COMMUNITY DEVELOPMENT DEPARTMENT  
80 Columbia Avenue ♦ Marysville, WA 98270  
(360) 363-8100 ♦ (360) 651-5099 FAX

Re: Marysville Corporate Center – *Technical Review 1*  
PA 22004

RE: Marysville Corporate Center, File# PA22-004  
Binding Site Plan  
15908 47<sup>th</sup> Ave., Multiple Parcels

C1.33

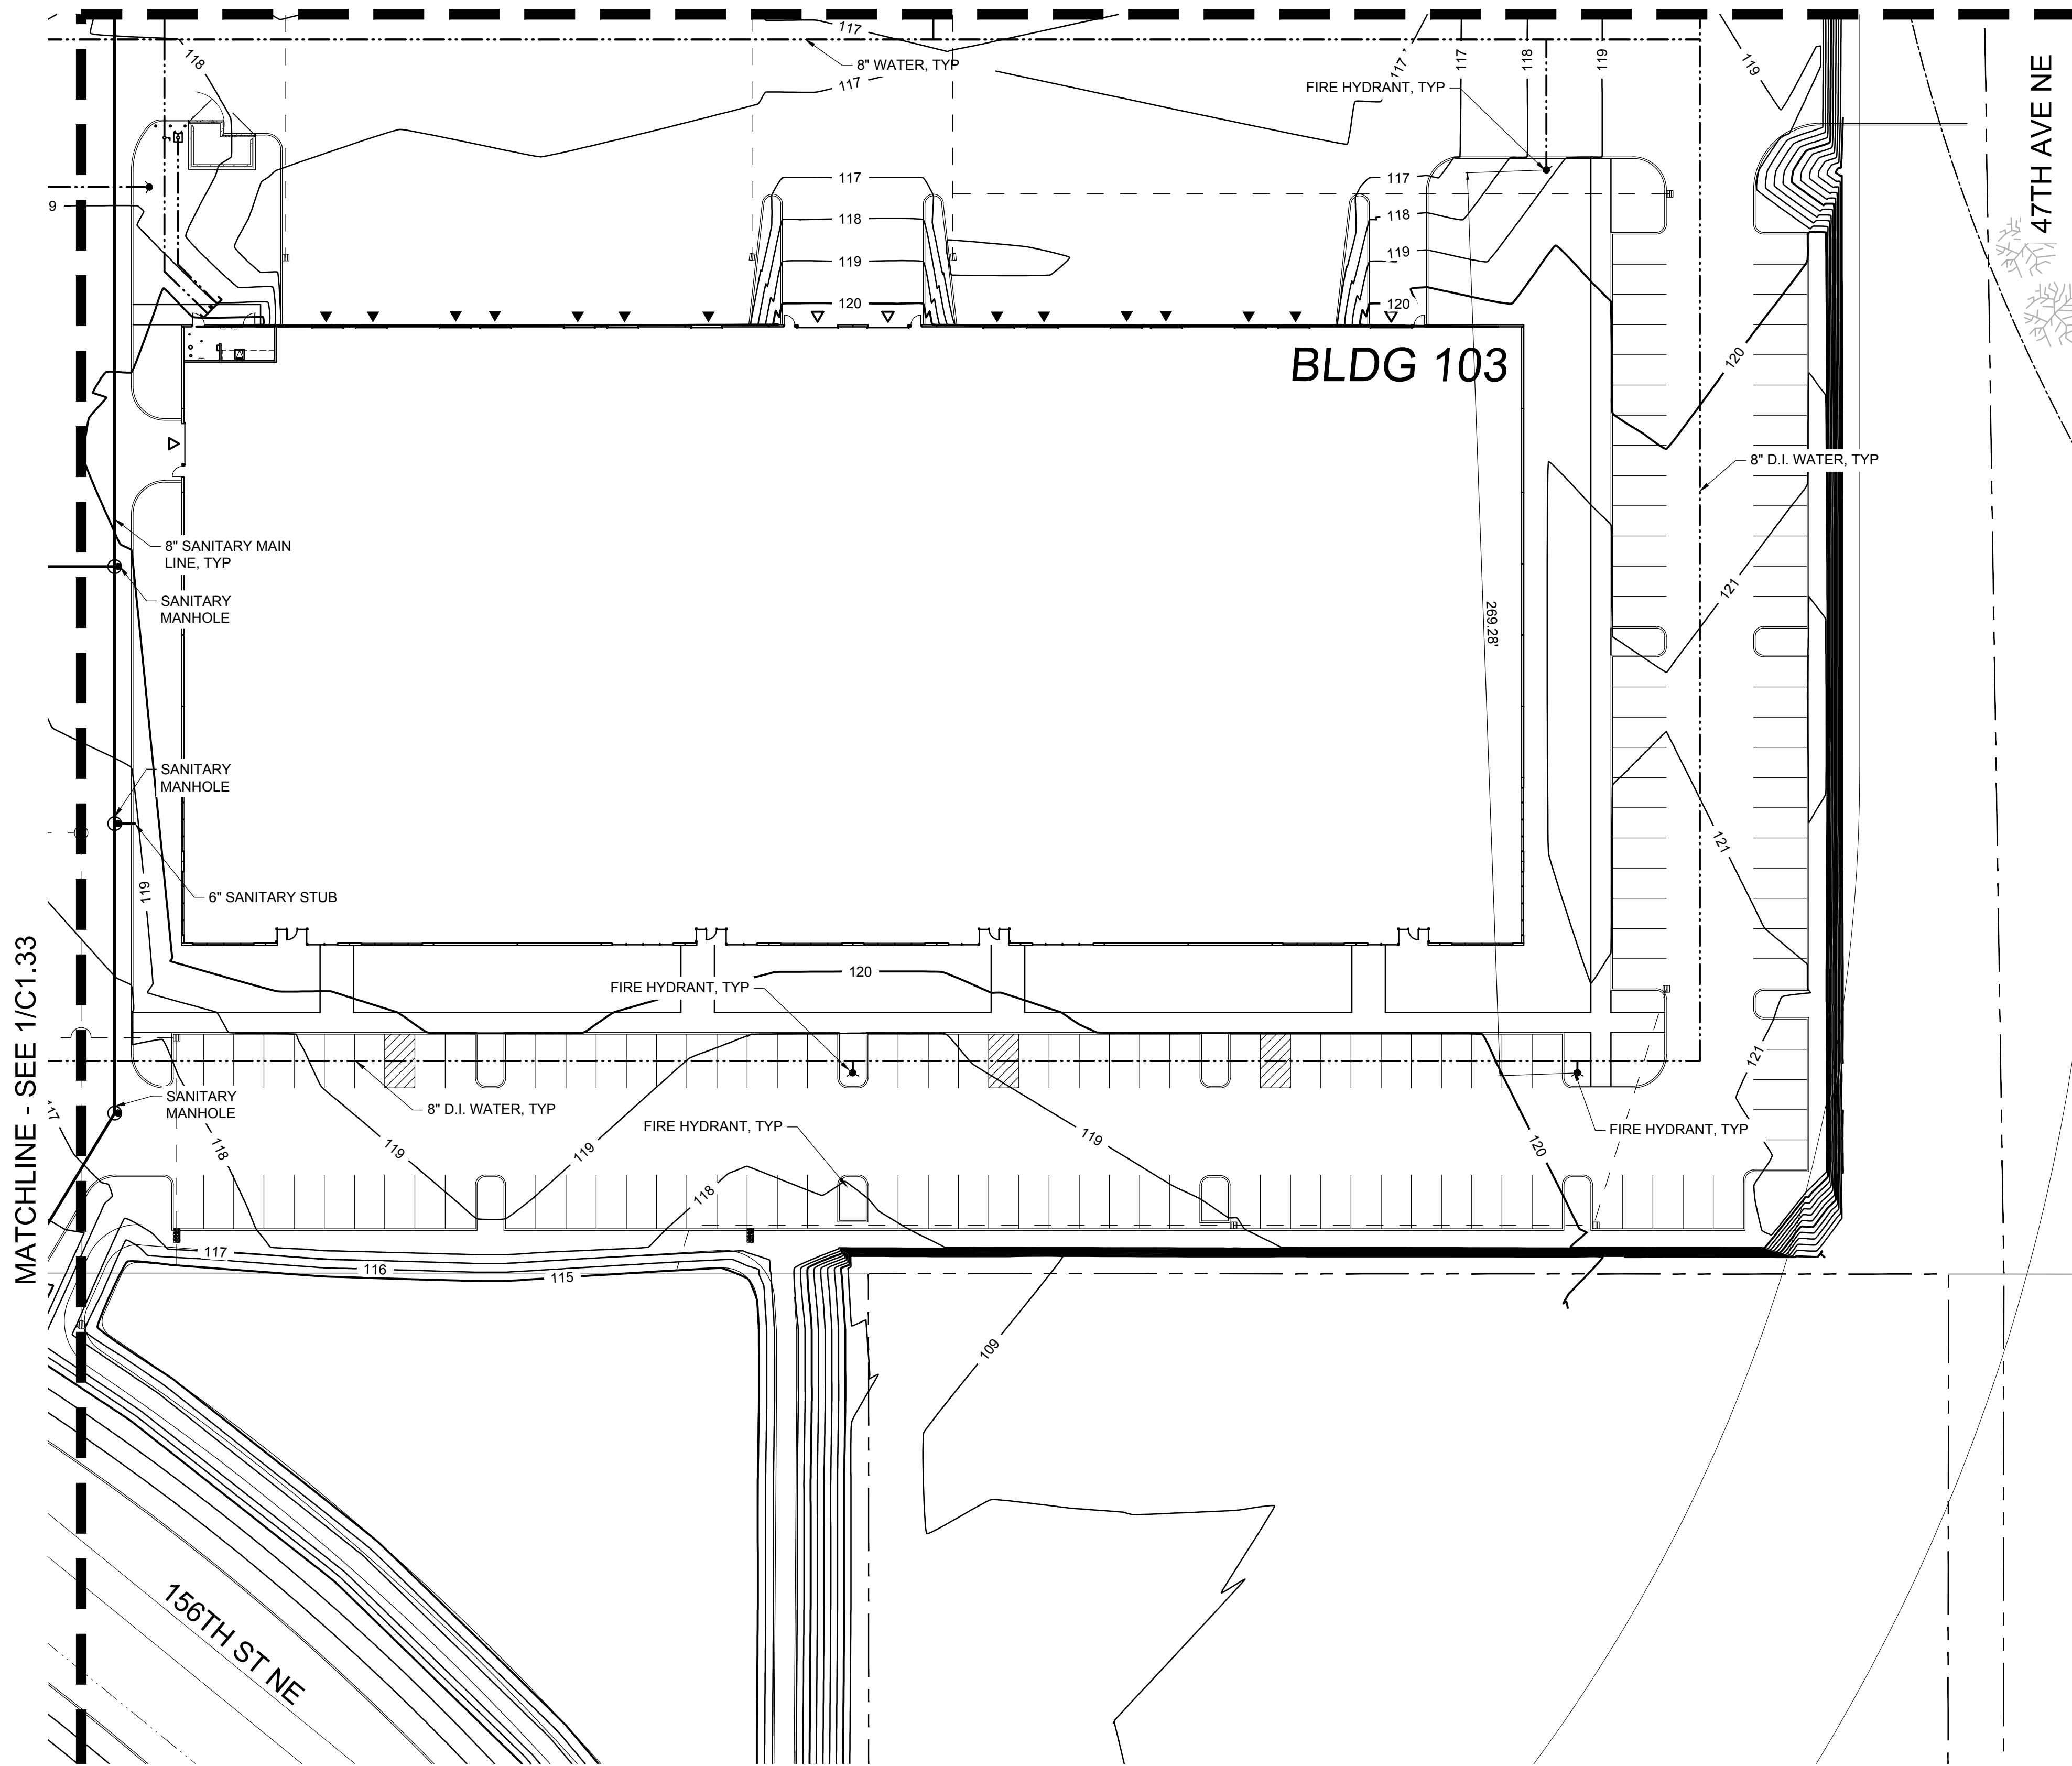
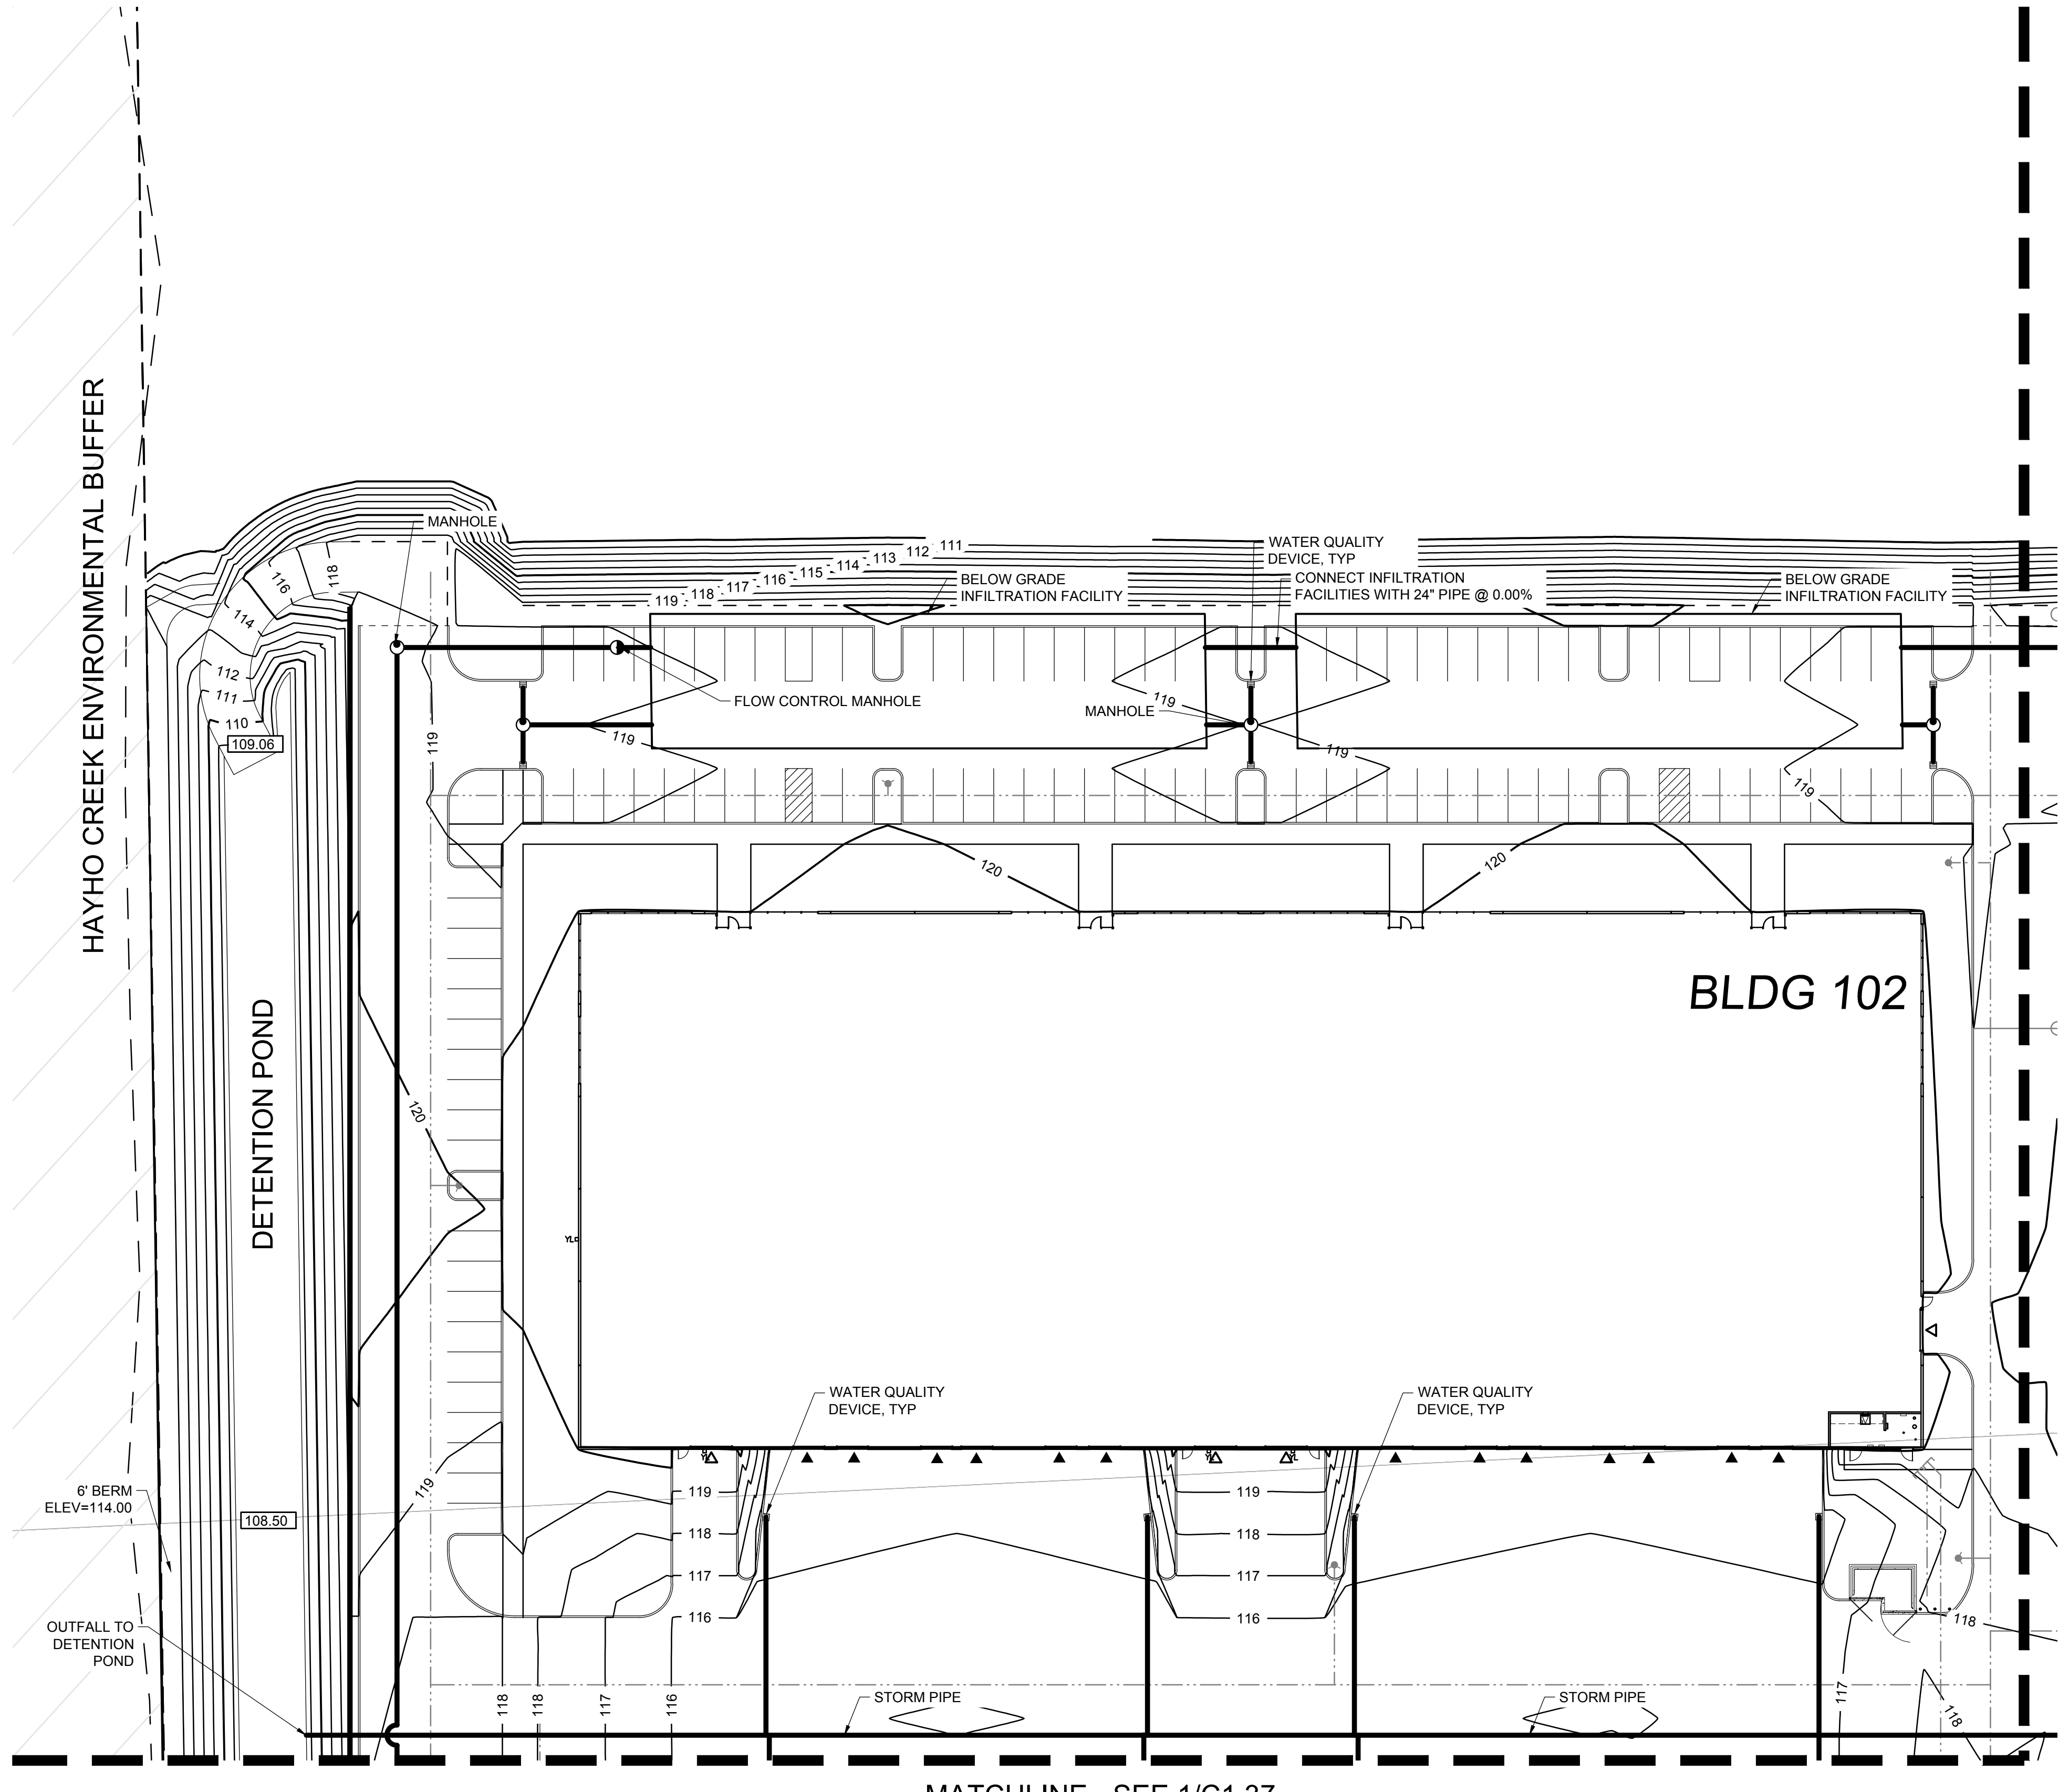
1. **Existing utilities:**
  - a. Sanitary sewer: The sewer manhole in 156th Street NE adjacent to the project is shown on RD325. The 18 inch trunk line, west of the project is shown on record drawing S619.

- b. Water: The waterline within 156th Street NE is available on RD325.
  - c. Storm: The storm drainage in 156th Street NE is also on RD325.
2. Per MMC 14.03.250, utilities are to be extended along the street frontages of the proposed project. Sanitary sewer and water mains shall be installed within the new City roads. Storm drainage facilities shall also be supplied for the new City roadways that are to be constructed.
